Department of Primary Industries

OUT15/30169

**WestConnex M4 East Project (SSI_6307)
Response to exhibition of Environmental Impact Statement**

WestConnex M4 East Project (SSI_6307) Response to exhibition of EIS Detailed comments - DPI Water

Figure 6.12 **Run 108 calibration plot of computed versus observed head (metres).**

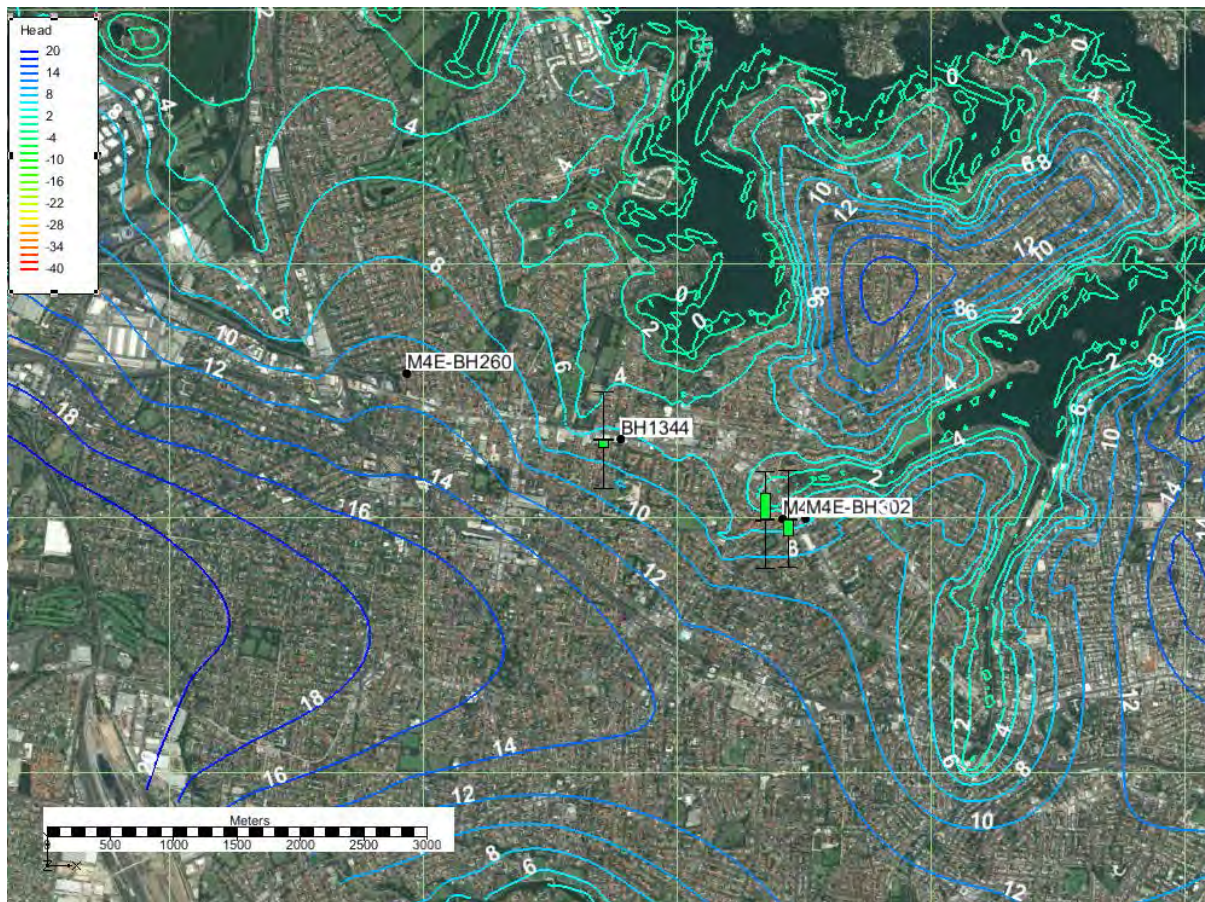
There is an attempt in Figures 6.11 and 6.12 to present an assessment of computed versus observed heads. However, these diagrams have no ‘key’ so that their meaning is unclear, and further with such a limited data set – maximum 2 values – a very close alignment of outcomes to inputs would be expected.

- iv. A comprehensive statistical evaluation of the model's calibration in accordance with the *Australian Groundwater Modelling Guidelines* by Barnett *et al.*, Australian National Water Commission, 2012.

Figure 7.1 Groundwater monitoring locations

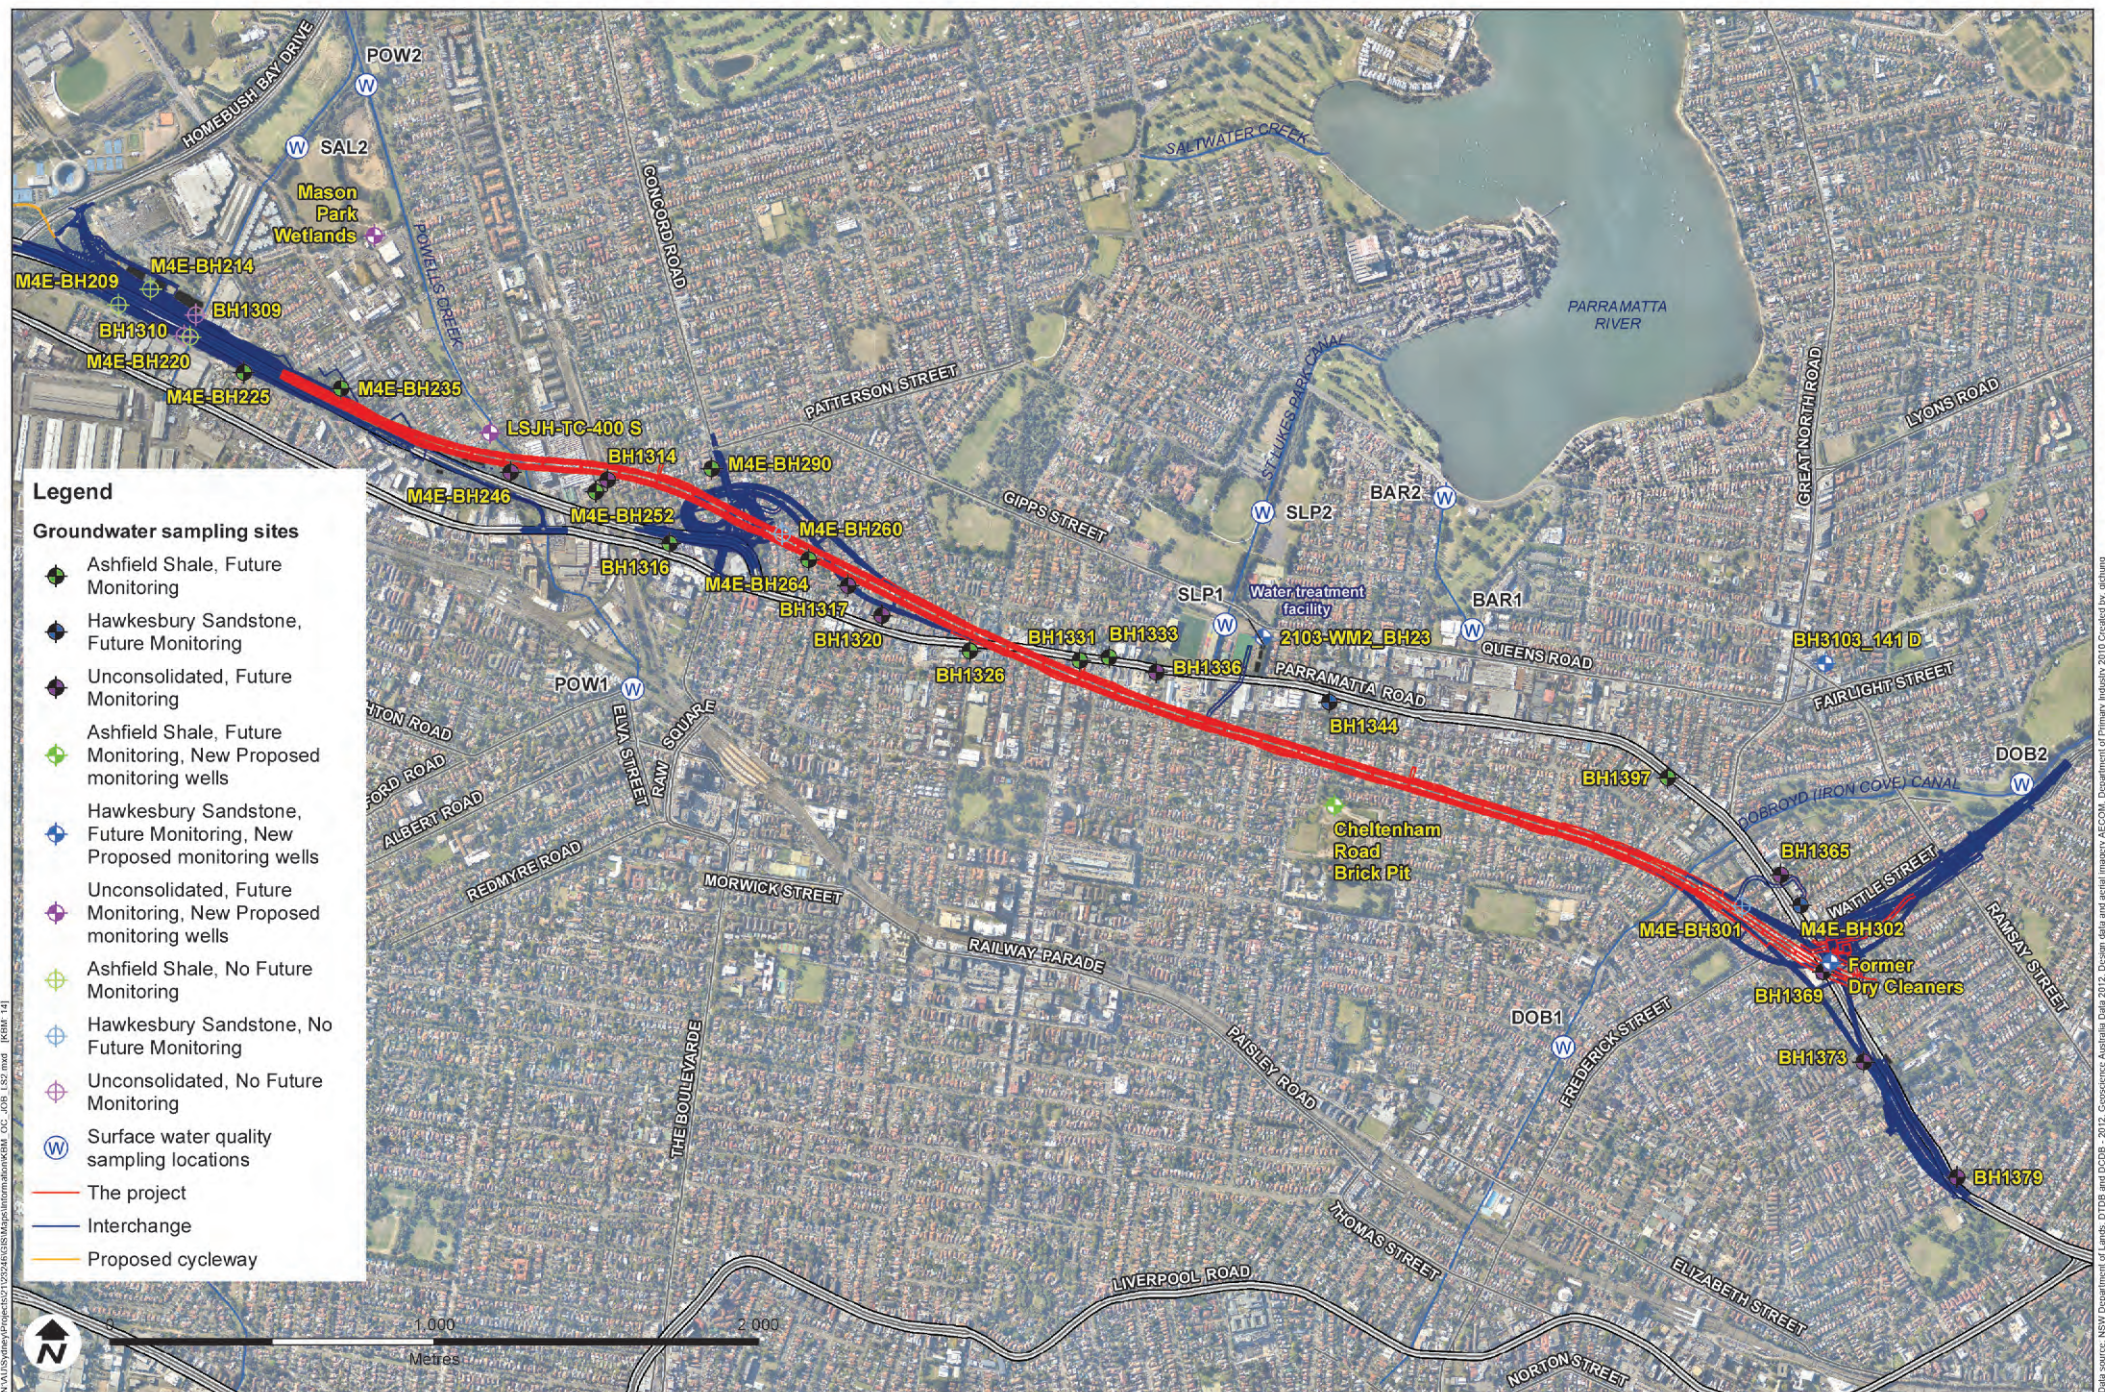
- Details of future monitoring bores and their equipping with data loggers are not provided (they are generally discussed in Section 7.4.2). Figure 7.1 indicates the general spatial relationship of the bores.

- i. Replacement bores for any loss of monitoring bores due to construction. A clearer listing of present and proposed monitoring bores is required, including their specification in 3 dimensions and details of their construction and borelogs.
